Heritage Advice

Bicester Heritage: Alterations to Buildings 81, 97, 2.no tank stores, construction of new bin store, and car port – Reference 19/00146/LB

Garry Campion, Senior Conservation Officer

21.2.2019

Project Title	Bicester Heritage		
Drawing Title	Bin store by Hangar 137 Existing and Proposed		
Project Ref.	1680		
Drawn	LW	Approved	
Checked		Date	Jan 19
Scale at A1	1:50		
Drawing Number	PL315	Rev

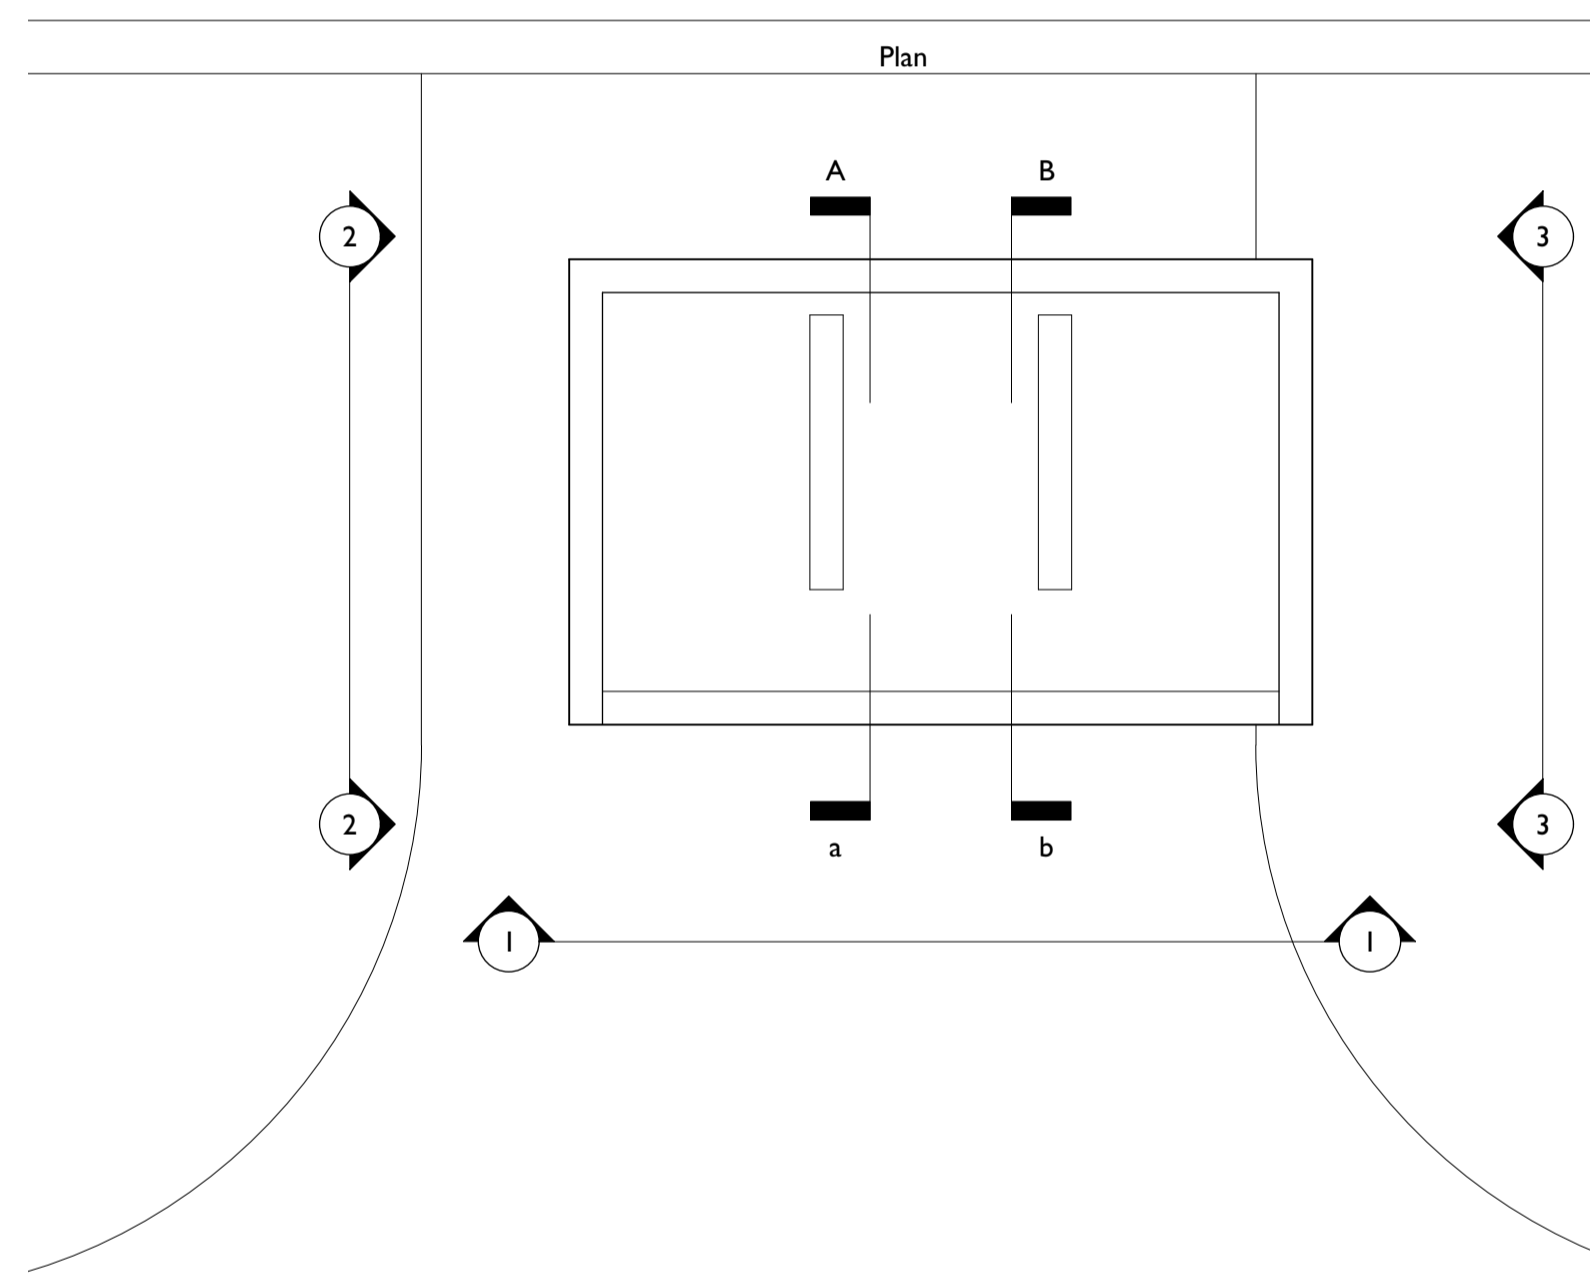
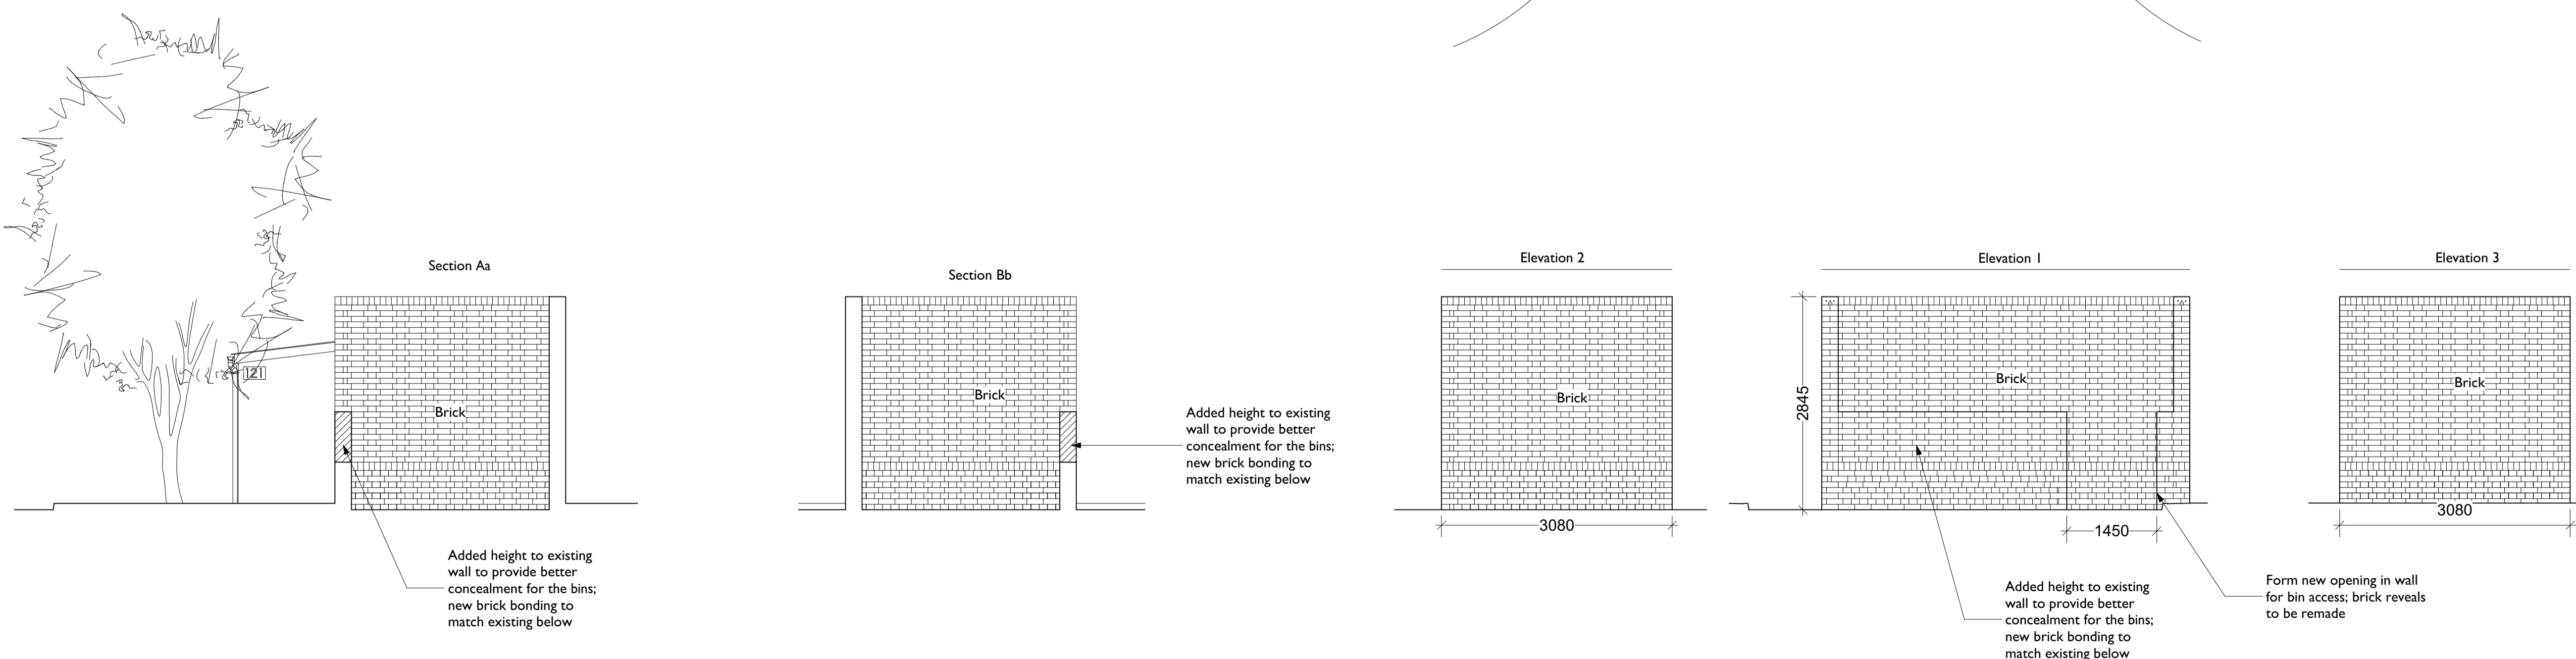
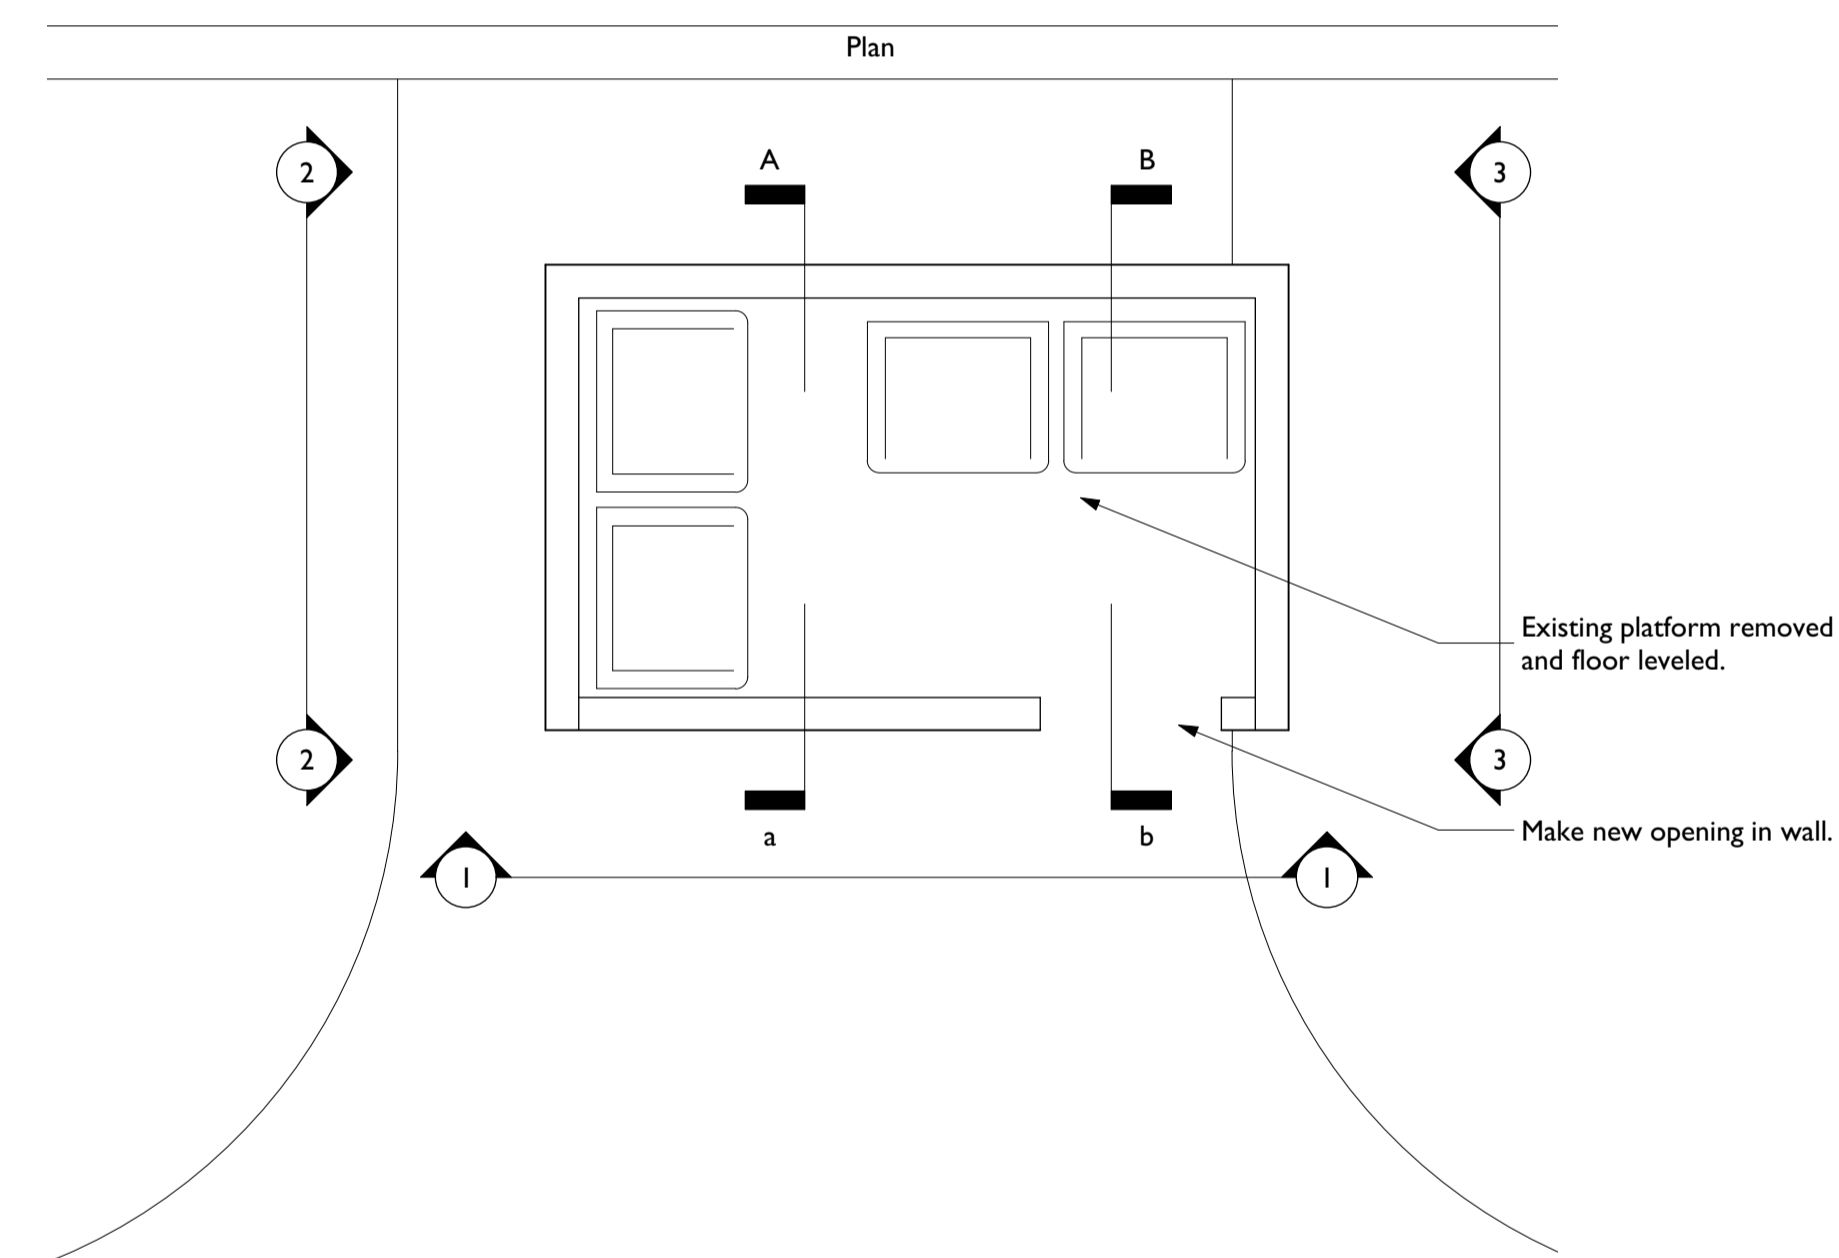
Discussed with Jonty Ashworth during a site visit, the proposal to re-use the two brick tank installations as brick stores is supported. Both structures are currently unused, and the proposal is a valuable means of bringing both back into use, which also contributes to their conservation. With the tank store to Building 137, it was suggested that the brick salvaged from creating the opening, and also originally to support the tank, would be used to raise the height of the front wall, which would also serve to hide the bins. With the tank to Building 108, this would necessitate the forming of an opening, which again is supported. It is considered that the proposed change of use and alterations will not harm the setting of heritage assets.
